Ribble Valley Borough Council
Housing & Development Control

Your ref: 3/2023/0222
Our ref: D3.2023.0222
Date: 15th May 2023

Application no: **3/2023/0222**

Proposal: **Proposed conversion and alterations to existing building to create one dwelling, including limited demolition, extension and re-modelling.**

Client Mr Hall and Miss Reece		
Project Proposed Conversion of Garage/ Stores off Back Brennand Street Clitheroe BB7 2HB		
Drawing Title Proposed Plans		
Scale 1:100/50 @A2	Date Jan 2023	Drawn LFR
READ DESIGN LTD		
152 - 02 A

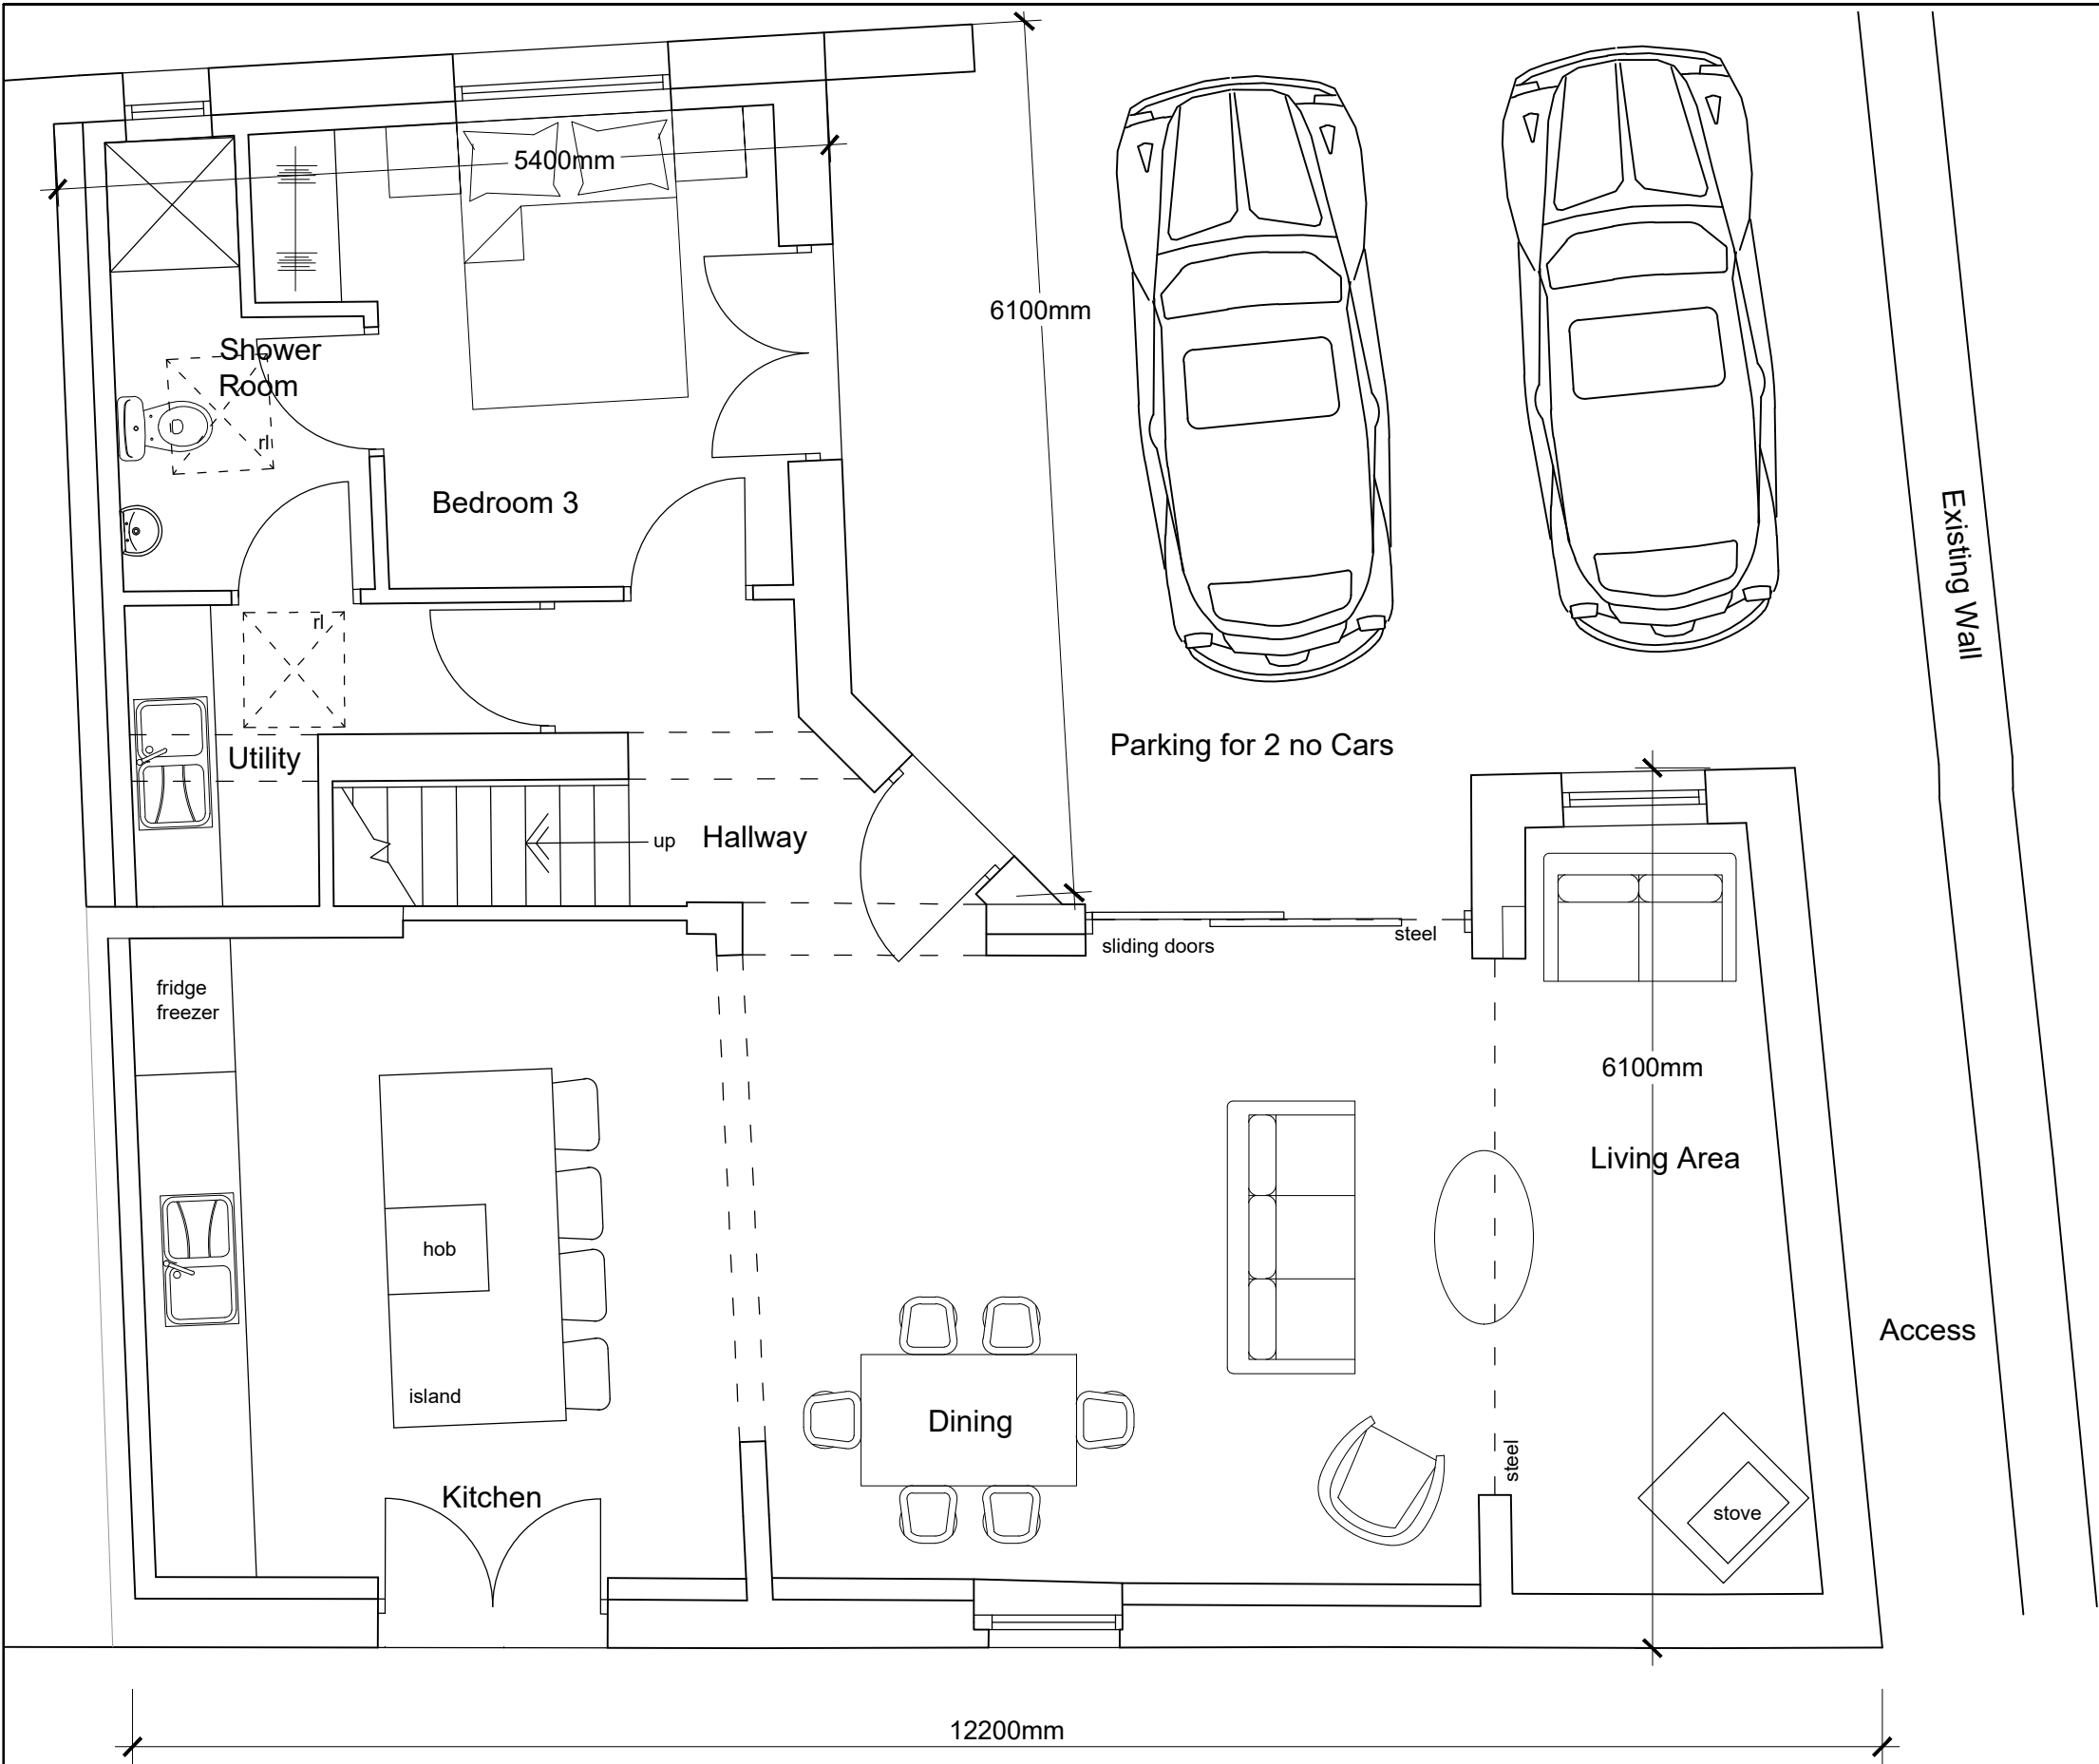
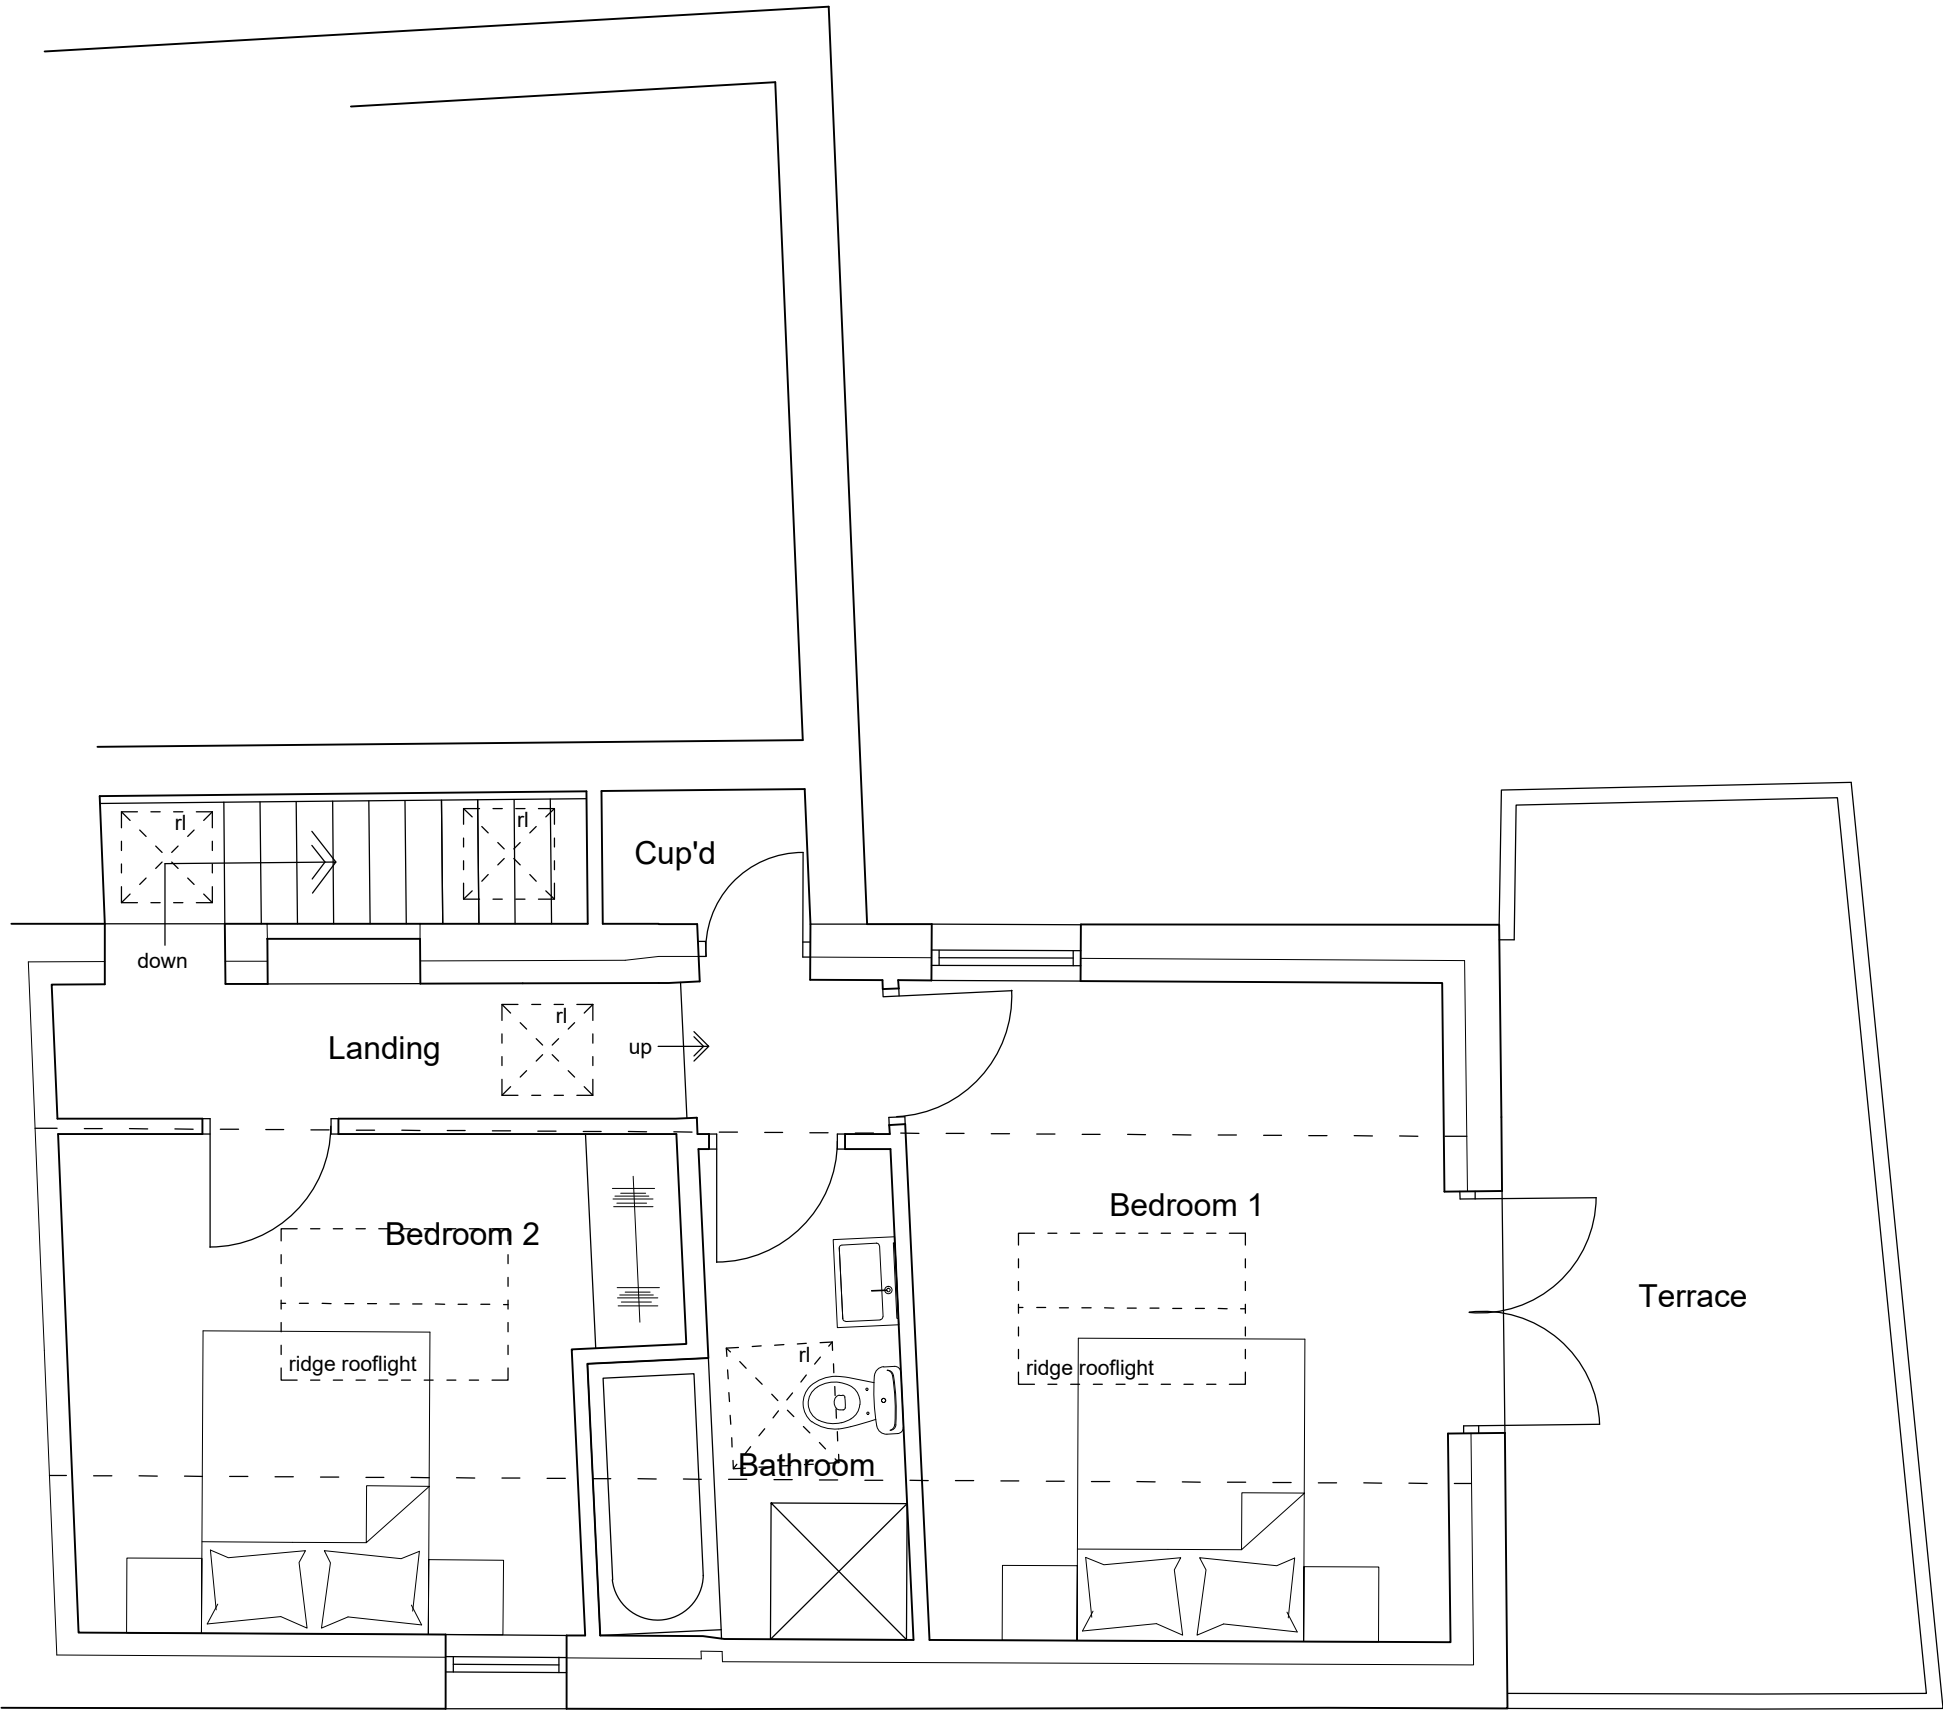
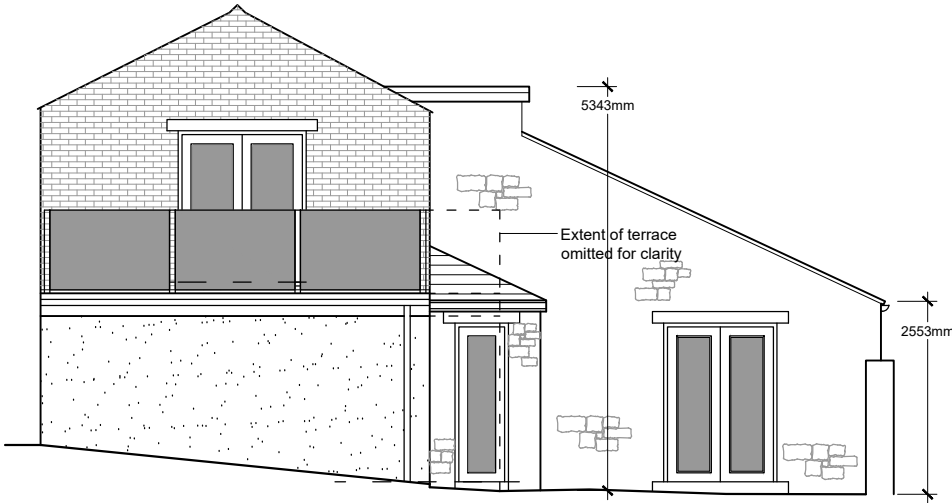
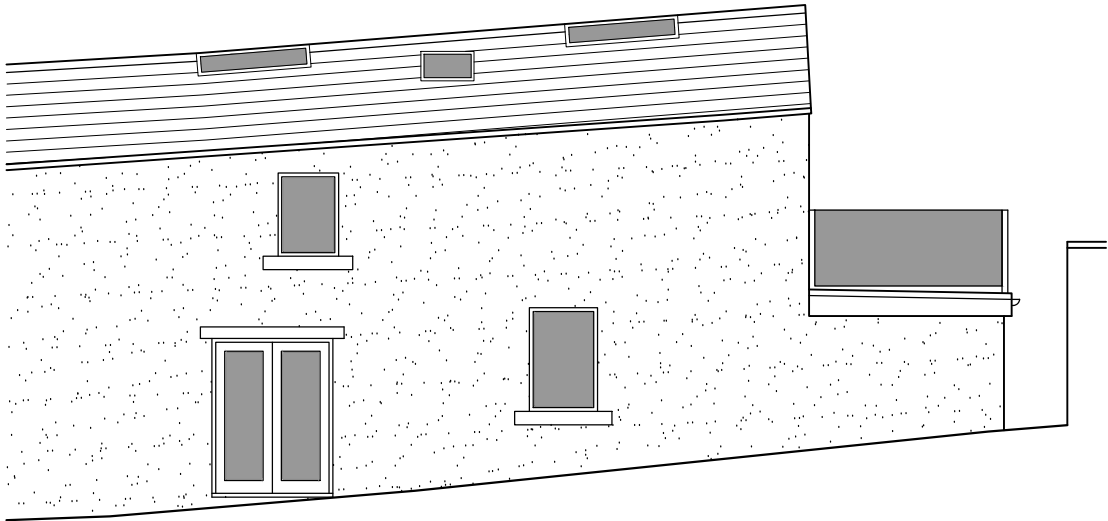
The LHA have reviewed Read Design drawing number 152-02A titled "Proposed Plans" and are aware that the access width complies with the LHAs guidance.

The LHA are also aware that the site can provide 2 car parking spaces for the 3-bed dwelling. This complies with the LHAs parking guidance as defined in the Joint Lancashire Structure Plan and so the LHA have no objection to the proposal.

2. No part of the development hereby permitted shall be occupied until such time as the access arrangements shown on Read Design drawing number 152-02A have been implemented in full.

4. The development hereby permitted shall not be occupied until such time as the parking and turning facilities have been implemented in accordance with Read Design drawing number 152-02A. Thereafter the onsite parking provision shall be so maintained in perpetuity.
